RE: BARCELONA COURT - FLOOD-PROOFING

REF: BARCELONA COURTS FLOOD PROOFING CERTIFICATION (REC'D 10-28-83)

RE: Barcelona Courts Flood Proofing Certification

FLOOD PROOFING PLAN

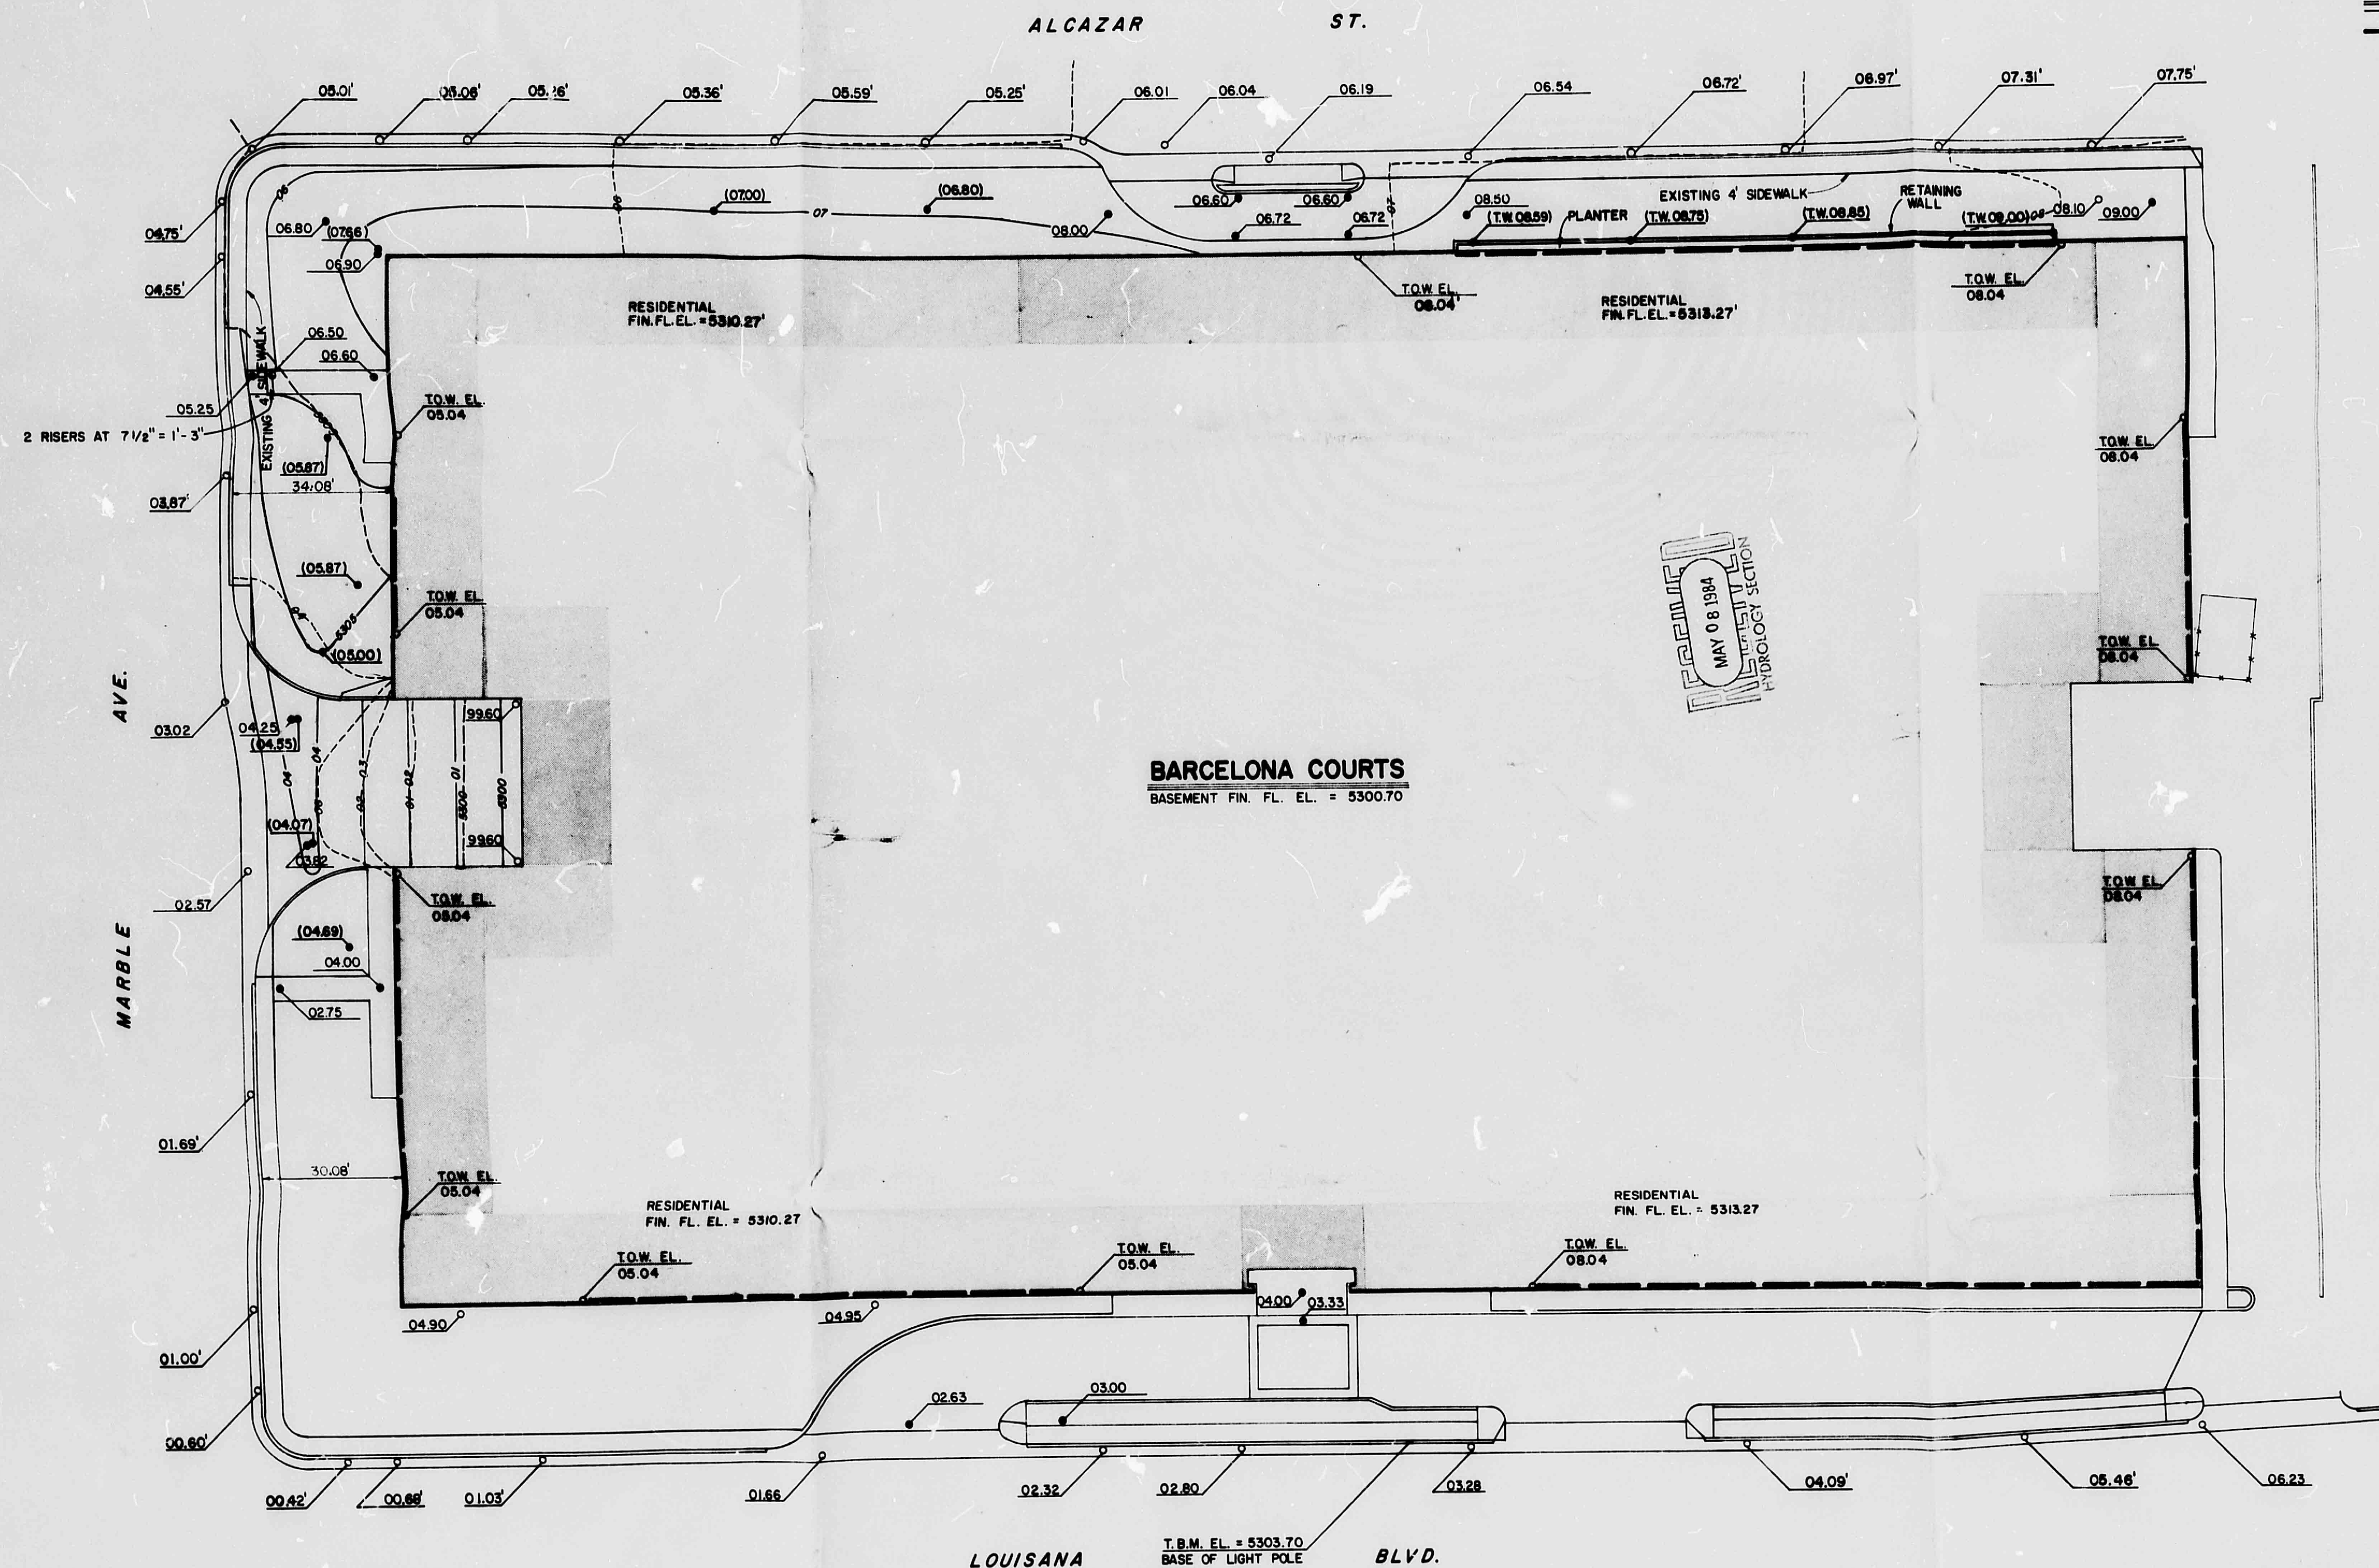
This letter is to certify that the flood-proofing of Barcelona Court has been completed in general conformance with the approved flood-proofing plan. A variation from the approved plan is the use of a landscaping wall in lieu of the proposed earthen berm along the south-east side of the building. The wall does perform the function of providing a barrier one foot above the anticipated flood level. Along the north side of the building, a berm has been installed to prevent water from entering the underground parking.

*1. Indicate FL & Elevation
2. Discuss the massive entrance
into the parking lot basement*

Attached are two copies of the proposed development for the Barcelona Court project. The grading changes indicated have been prepared to prevent flooding in the event of a 100-year storm. Flow line elevations adjacent to the curb and gutter are shown as existing elevations.

As shown, the finished floor elevation in the residential area of the building is well above the anticipated flood plain. It is possible, however, that some water could enter the basement area through the existing ventilation openings along the east and north sides of the building. The proposed grading changes will prevent the entrance of water and provide one foot of freeboard in the bermed areas. One and a quarter feet has been provided between the flow line and finished elevations at the main lobby entrance on Louisiana and the drive to the basement area adjacent to Marble. Both areas provide access to the basement area which is used for vehicle parking and contains a swimming pool facility. The entire basement area is graded to area drains then to a sump pump facility that can dispose of any water which may enter the basement area.
